Consultant Response to Planning Comments

Application Ref: AL/118/25/DOC – Condition 4

Site Name: Land to the north of The Haven and East of Northfields Lane, Westergate PO22 3UH

FLOW CONTROL CHAMBER

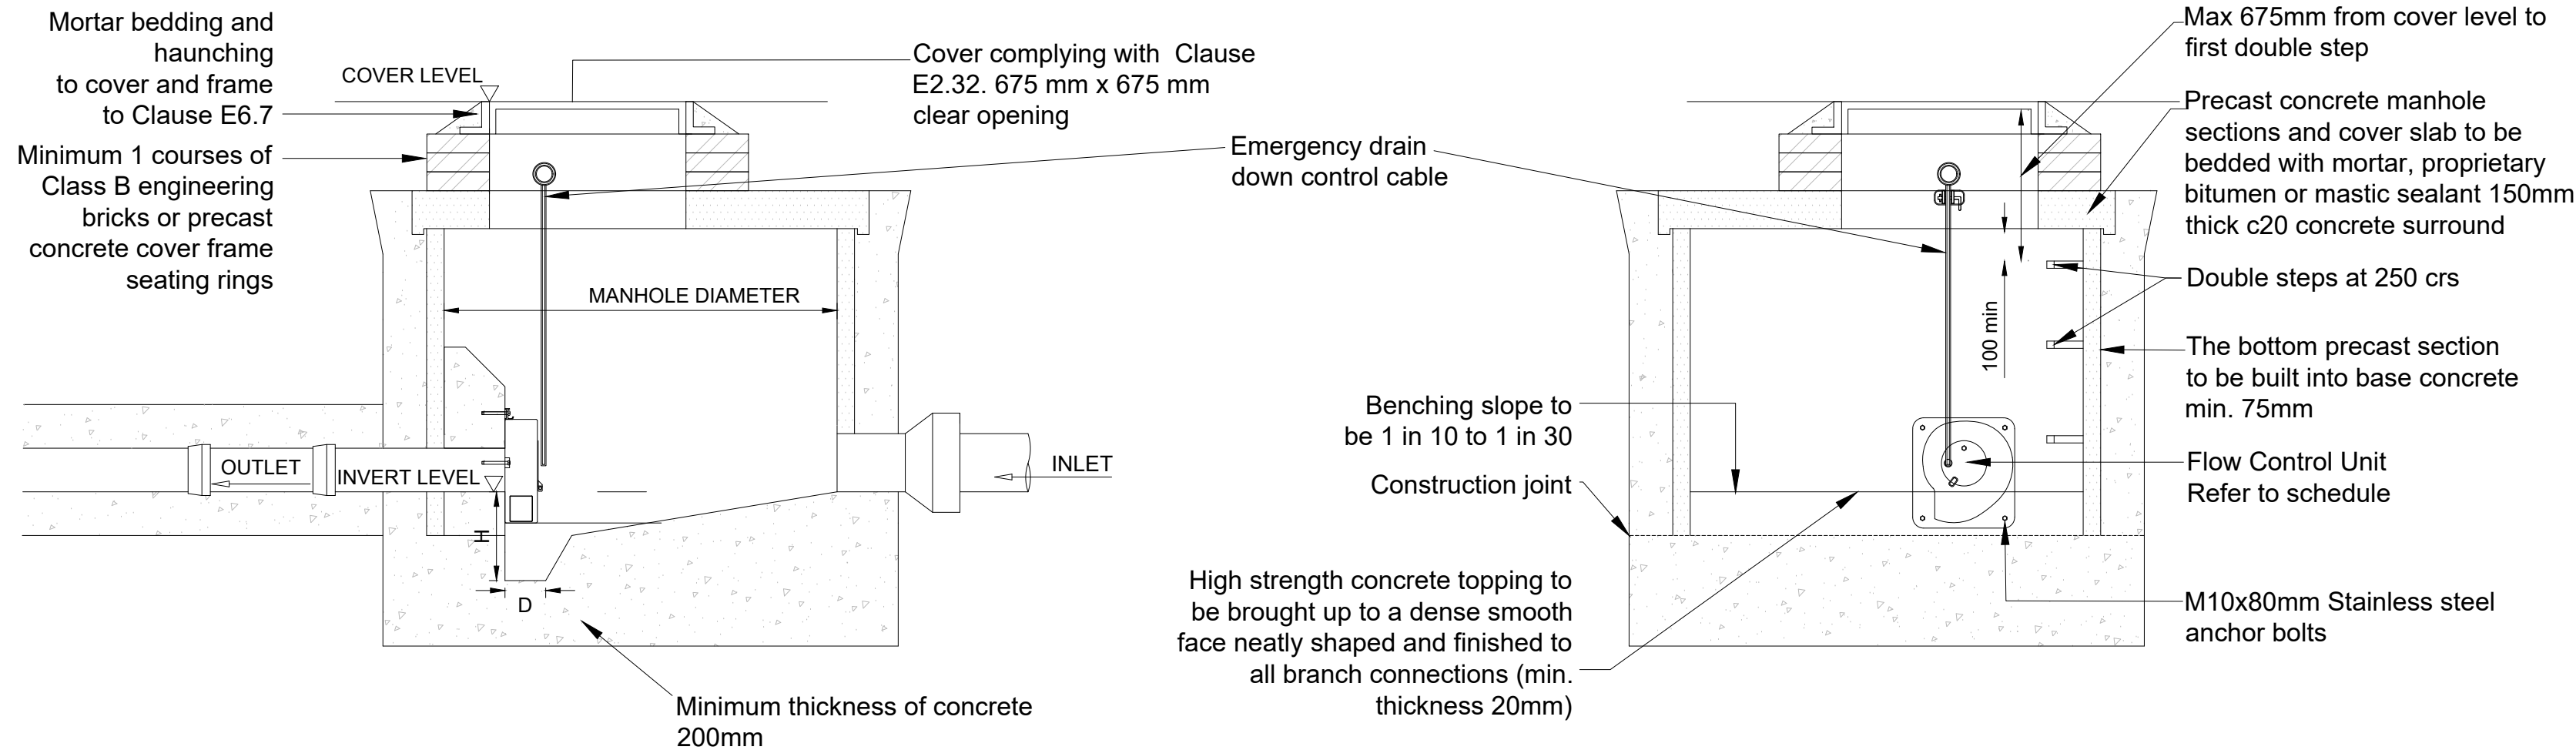
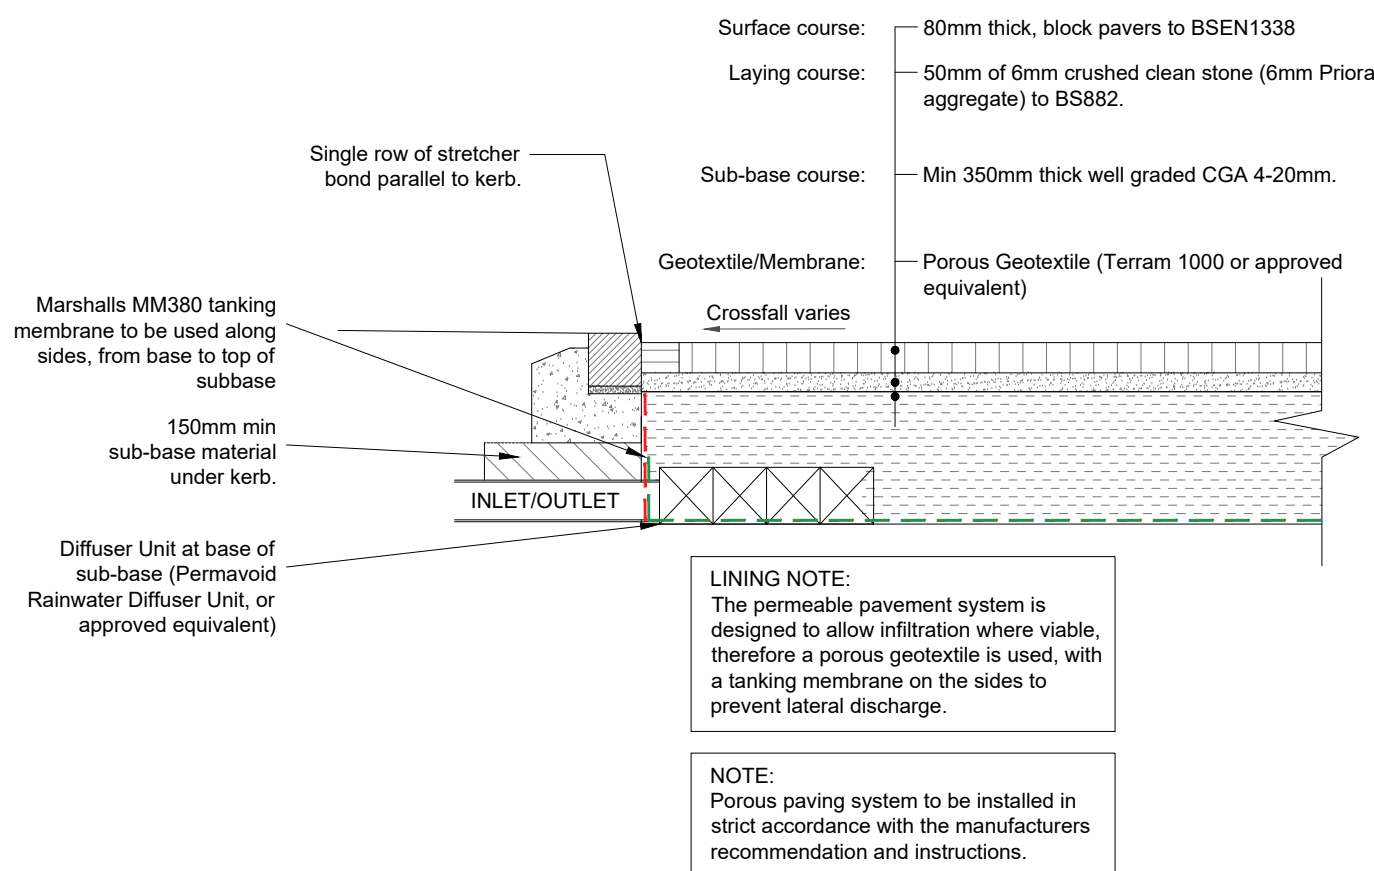
flow restriction should be based upon greenfield runoff equivalent for the drained area and if necessary a relaxation applied where constraints preclude meeting the GFR rate. Modern flow controls can achieve rates much lower than 1l/s.	○ inability to meet required 24-hour half-drain down times with very low discharge rates, ○ operational reliability under fine flow conditions, and ○ potential for surface water flooding due to blockage incidents. Industry Guidance cautions use of very low discharge rates due to the above reasoning, including but not limited to the National Standards for SuDS and CIRIA. It is worth noting also that discharge rates will be reduced by any viable infiltration within the permeable pavement (with allowance for infiltration not modelled but where possible provided for, as advised by ADC Drainage) as well as via rainwater harvesting.
6	The detailed drainage layout plans does not include finished surface levels. The base level of the permeable pavement storage should also be shown.	Finished surface levels are detailed in drawing 002 and base of permeable pavement are detailed in drawing 001 ; Harbourstone have also provided additional invert levels for completeness in updated plan.

Drawing No: 2025-C109-005 Rev: -

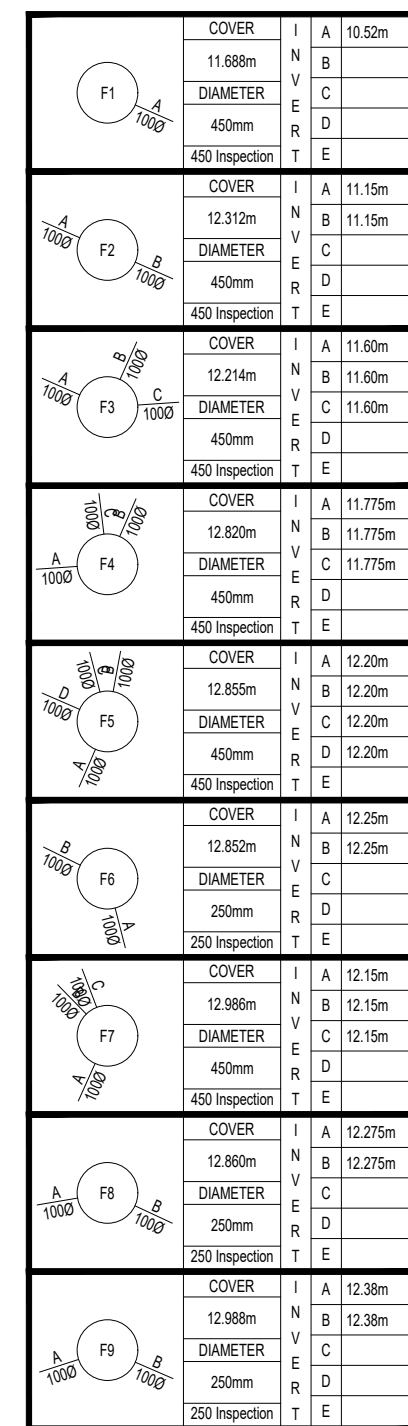
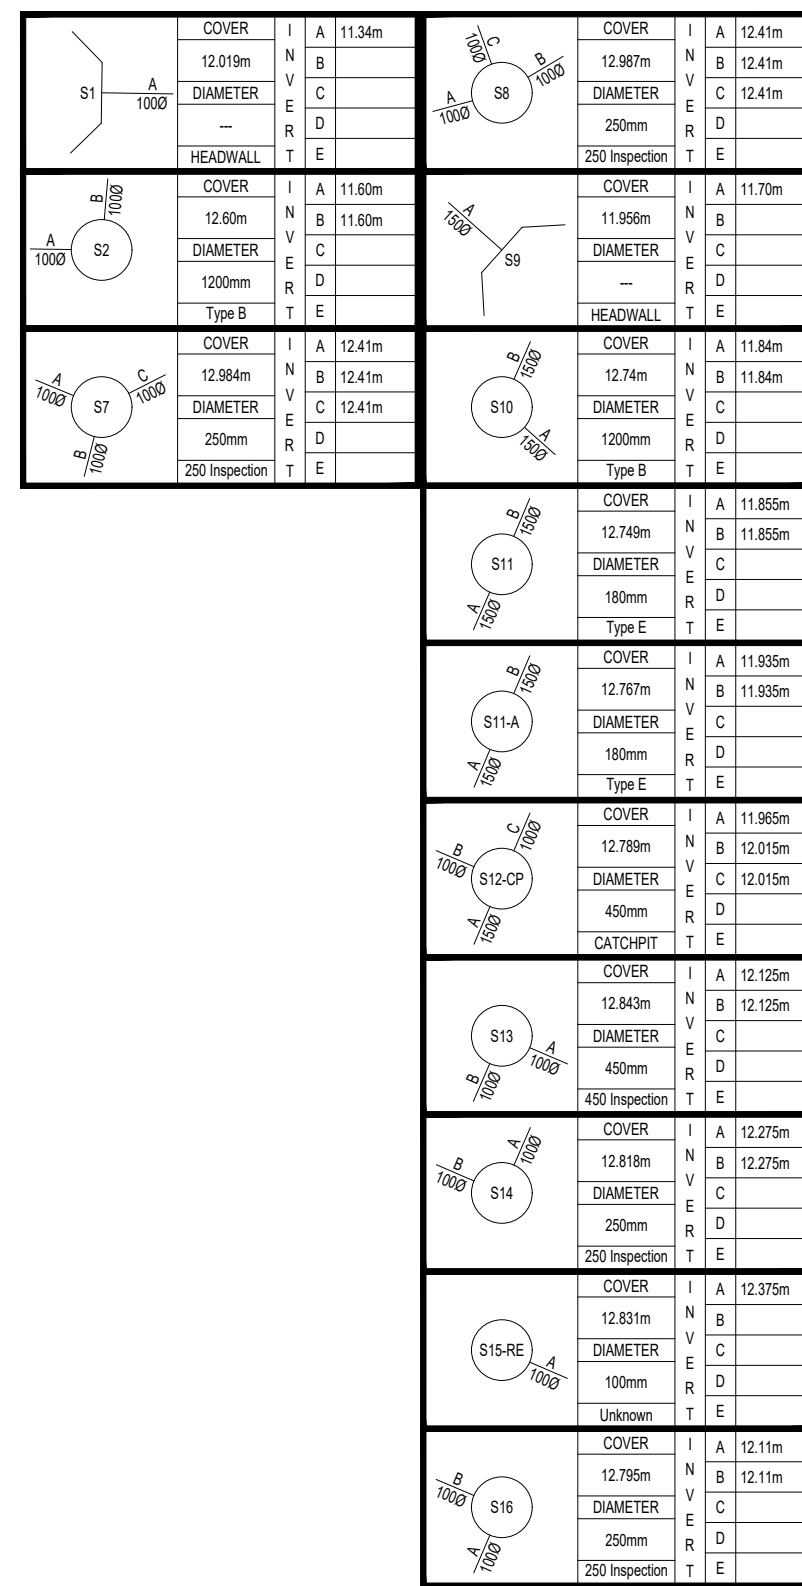
4	The planning condition requires an updated impermeable areas plan. None is submitted. This should include a summary and total including urban creep allowance.	The impermeable areas plan is shown within drawing 005 . This was previously submitted and does include a summary and total including urban creep allowance, so please re-review.
5	The proposed design peak outflow rates are arbitrary and not restricted to greenfield runoff rates in accordance with the National SuDS Standards. Design	Harbourstone has concerns about designing to very low discharge rates (e.g., <1 l/s) due to common technical and maintenance issues, including: ○ increased risk of blockage due to very small orifices,
